Your Ref 20/02446/F

Thursday 29 October 2020

Proposal: Formation of inland waterways marina with ancillary facilities building, car parking, access and associated landscaping including the construction of a new lake - re-submission of 18/00904/F

Location: Glebe Farm, Boddington Road, Claydon, Banbury

Drawing Title: **PROPOSED BUILDING**  
 Drawing Number: **A05/405 B**

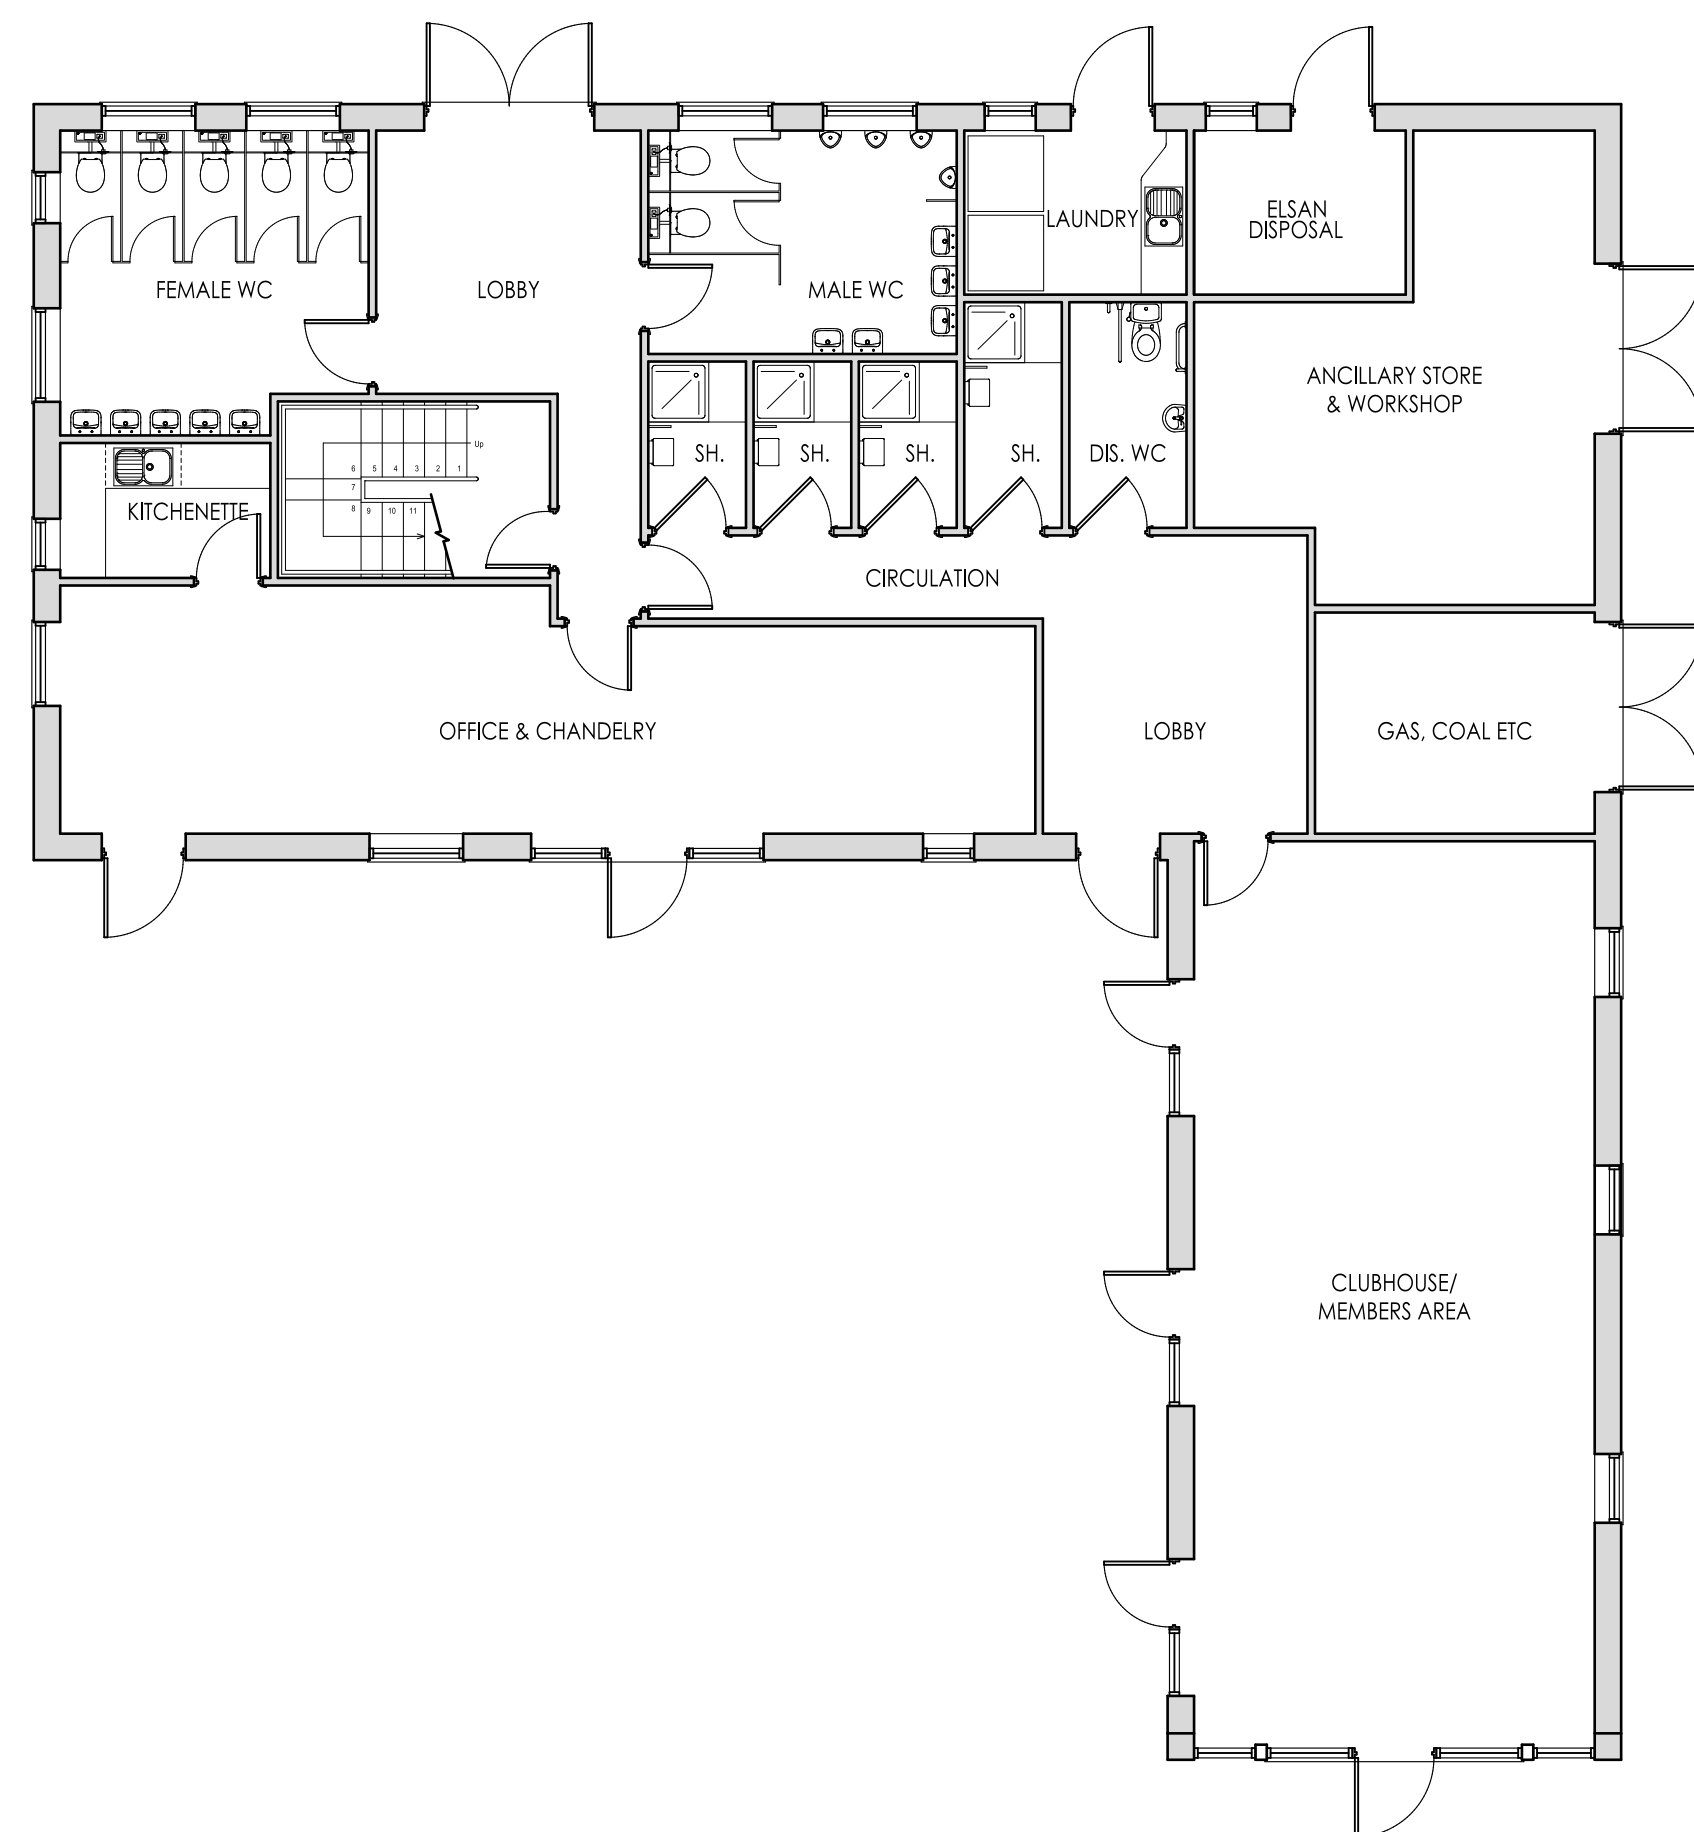
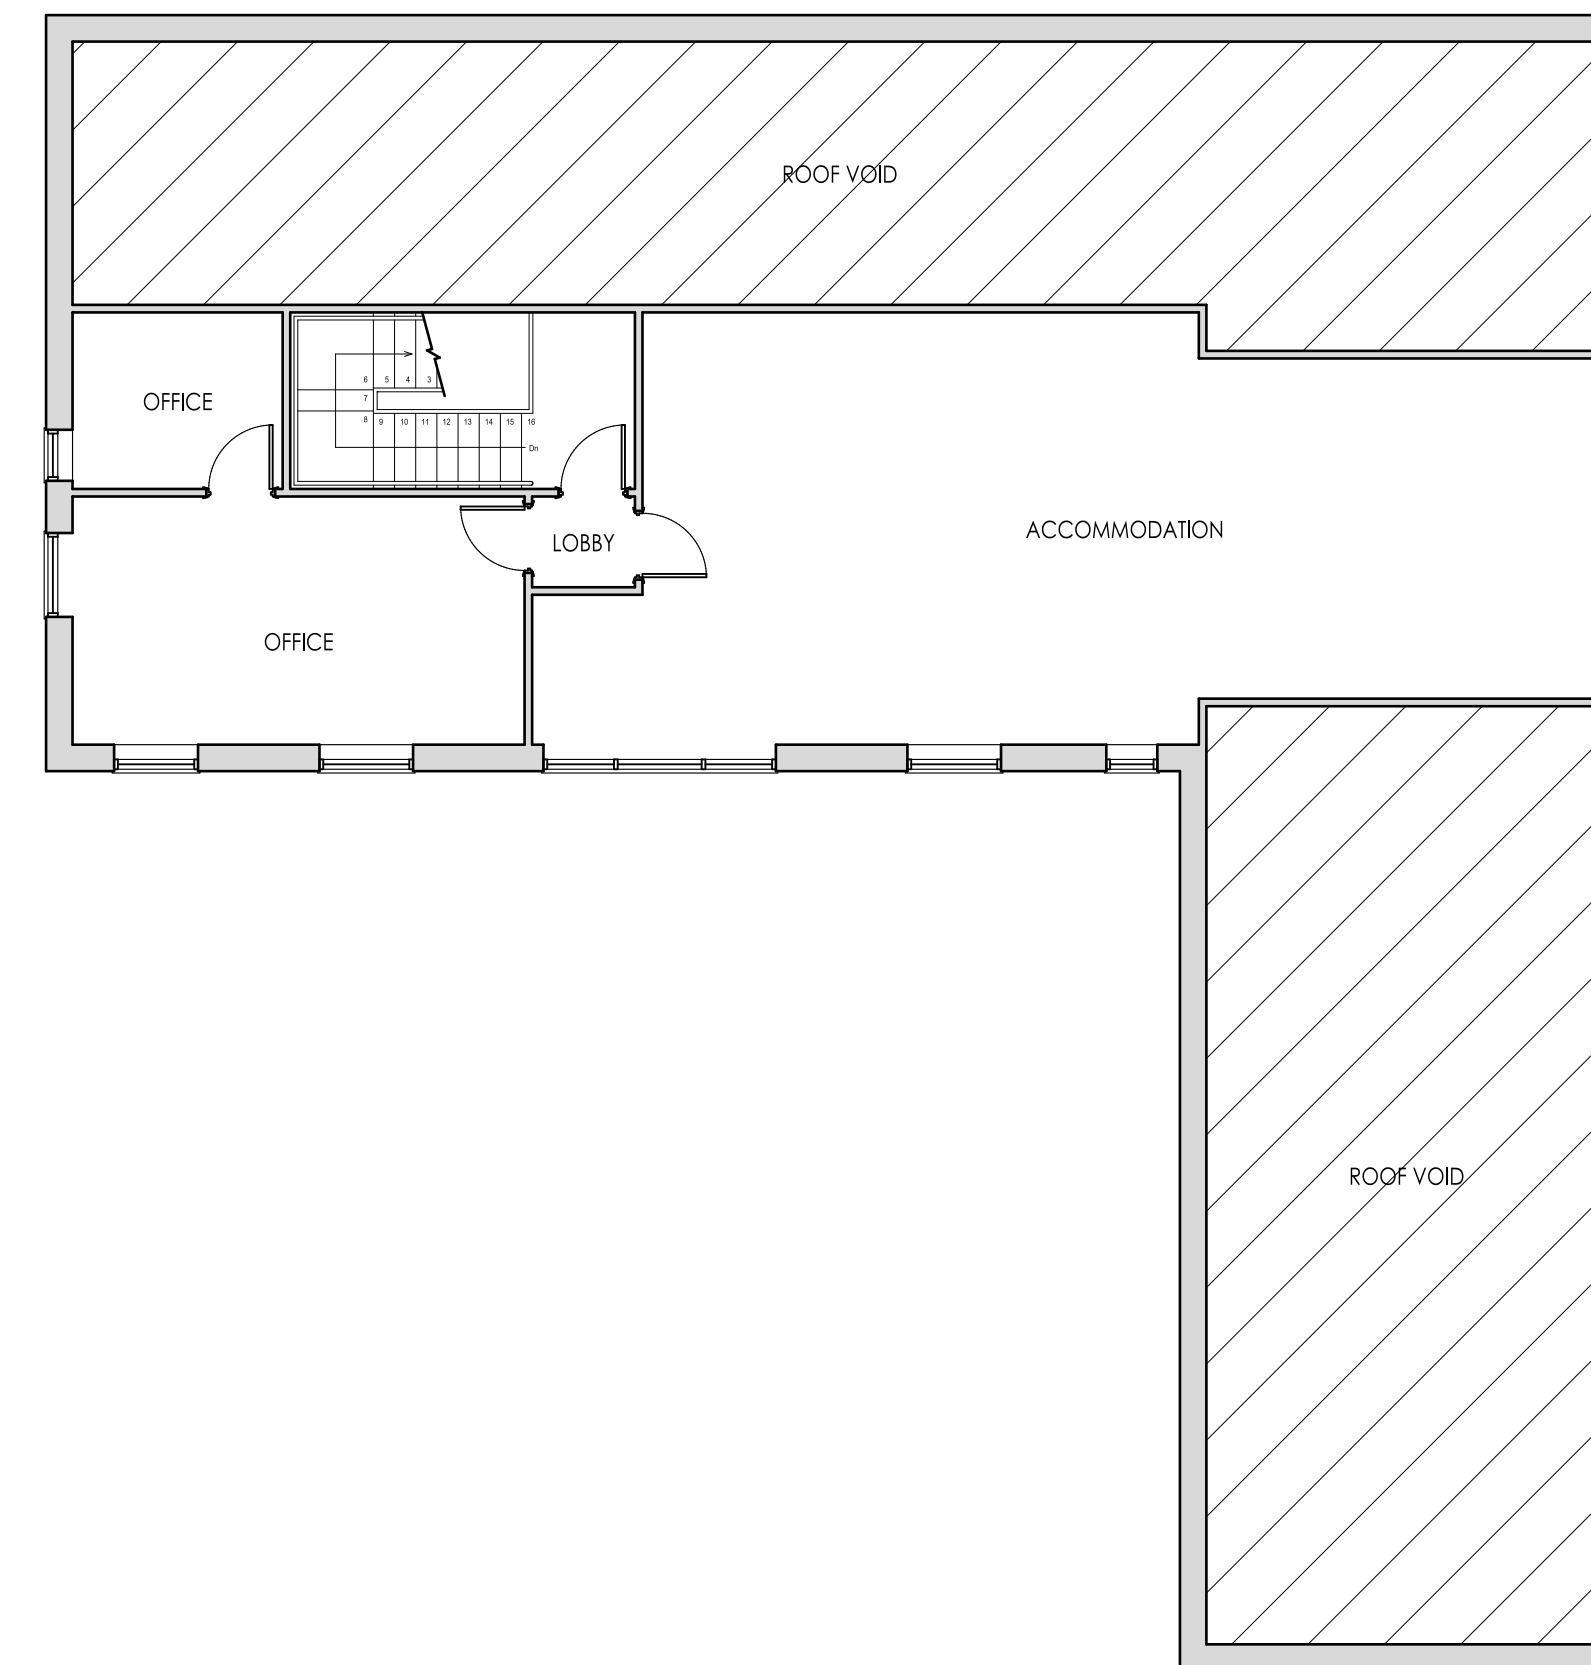
The design of the proposed clubhouse is acceptable and resembles a converted barn, or other agricultural building.

It is noted that an Elsan disposal point is provided within the facilities building, however, it is not clear from the submitted floor plans and site plan where general waste or recycling is to be stored. This should be clarified, and details provided as windblown waste and pollutants can not only have a detrimental impact on the visual amenity of the canal corridor but also be detrimental to wildlife.
